# **OXFORDSHIRE COUNTY COUNCIL'S RESPONSE TO CONSULTATION ON THE FOLLOWING DEVELOPMENT PROPOSAL**

**Application no:** 15/01326/OUT

**Proposal:** OUTLINE - Up to 280 dwellings (including 30% affordable housing), introduction of structural planting and landscaping, formal and informal public open space and play areas, surface water flood mitigation and attenuation, new priority junction arrangements to White Post Road, creation of section of spine road to link Bloxham Road with White Post Road as well as creation of 34 space car park and other associated ancillary works. All matters reserved except for access

**Location:** OS Parcels 6741 And 5426 West Of Cricket Field North Of Wykham Lane Bodicote Oxfordshire

FIGURE B4 BASE: 2025
AM & PM PEAK HOURS
= B2 + B3

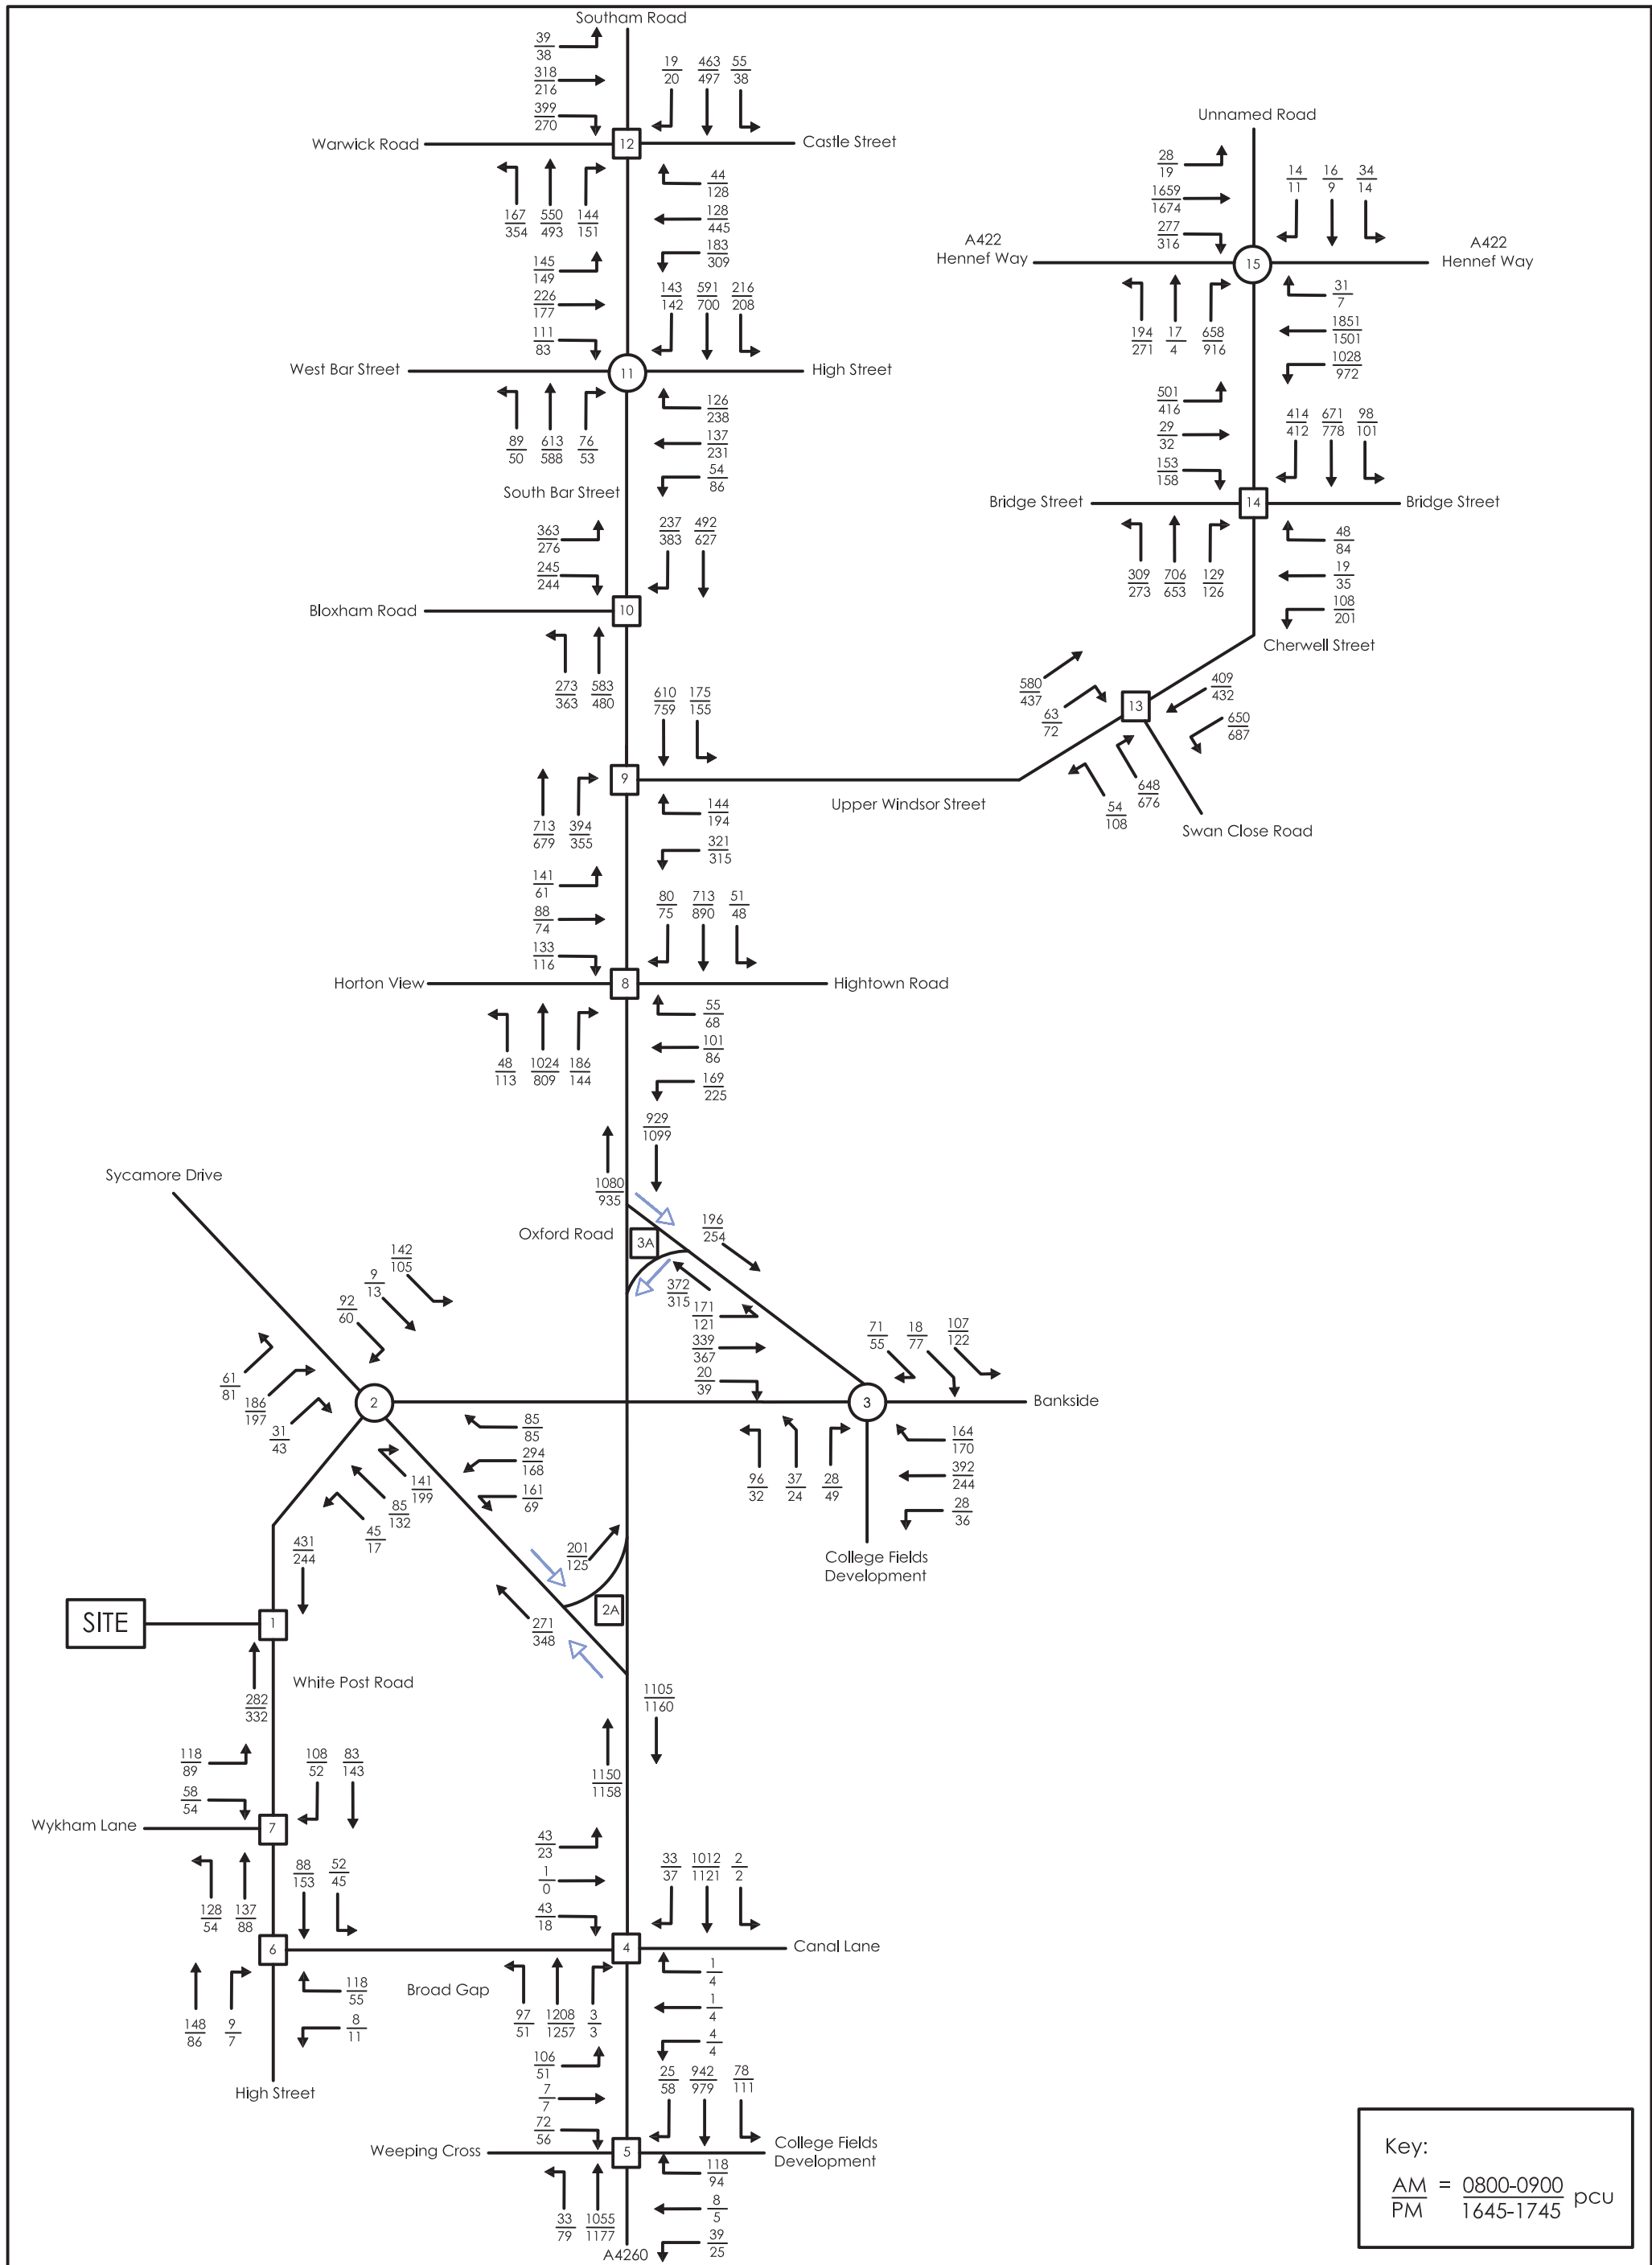
It is recognised that the all peak hour trips add to the Banbury transport network. I am still concerned about a significant impact in terms of the increase in queue lengths and delay at some junctions. At OCC's request the revised TA additionally includes assessment of the junction of Oxford Road/Farmfield Road, and Swan Close Road/Bankside/Hightown Road. (Concorde Ave/Cherwell Drive was also requested but the increase in traffic at the junction caused by the development has been shown to be low enough for the junction not to require assessment.)

I disagree with the TA's assertion that the proposed development does not lead to a material traffic impact at Junction 16. Although the junction is at a high Degree of Saturation in the 2025 base scenario, the addition of the development traffic takes it close to 100% saturation (98.5%) and adds 12 vehicles (almost doubling) to the queue on Oxford Road north Left/Ahead.

A contribution toward the Banbury Area Transport Strategy is required to mitigate the cumulative impact of planned growth by funding transport infrastructure and services which cannot be attributed to a single development, but which will benefit trips from this proposed development.
